Harnett County Department of Public Health Site Sketch

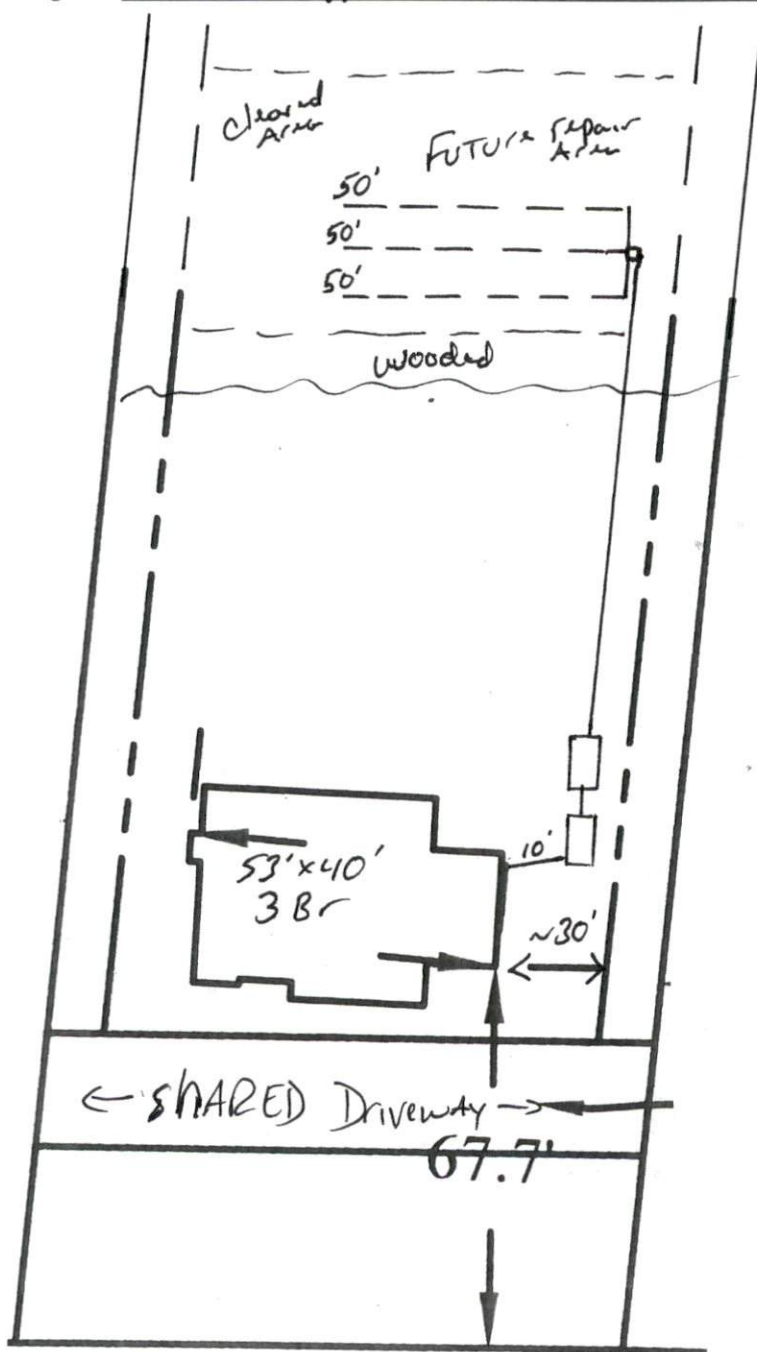
Handwritten: *cleared area*
 Show profile locations and other site features (dimensions, references or benchmark, and North)
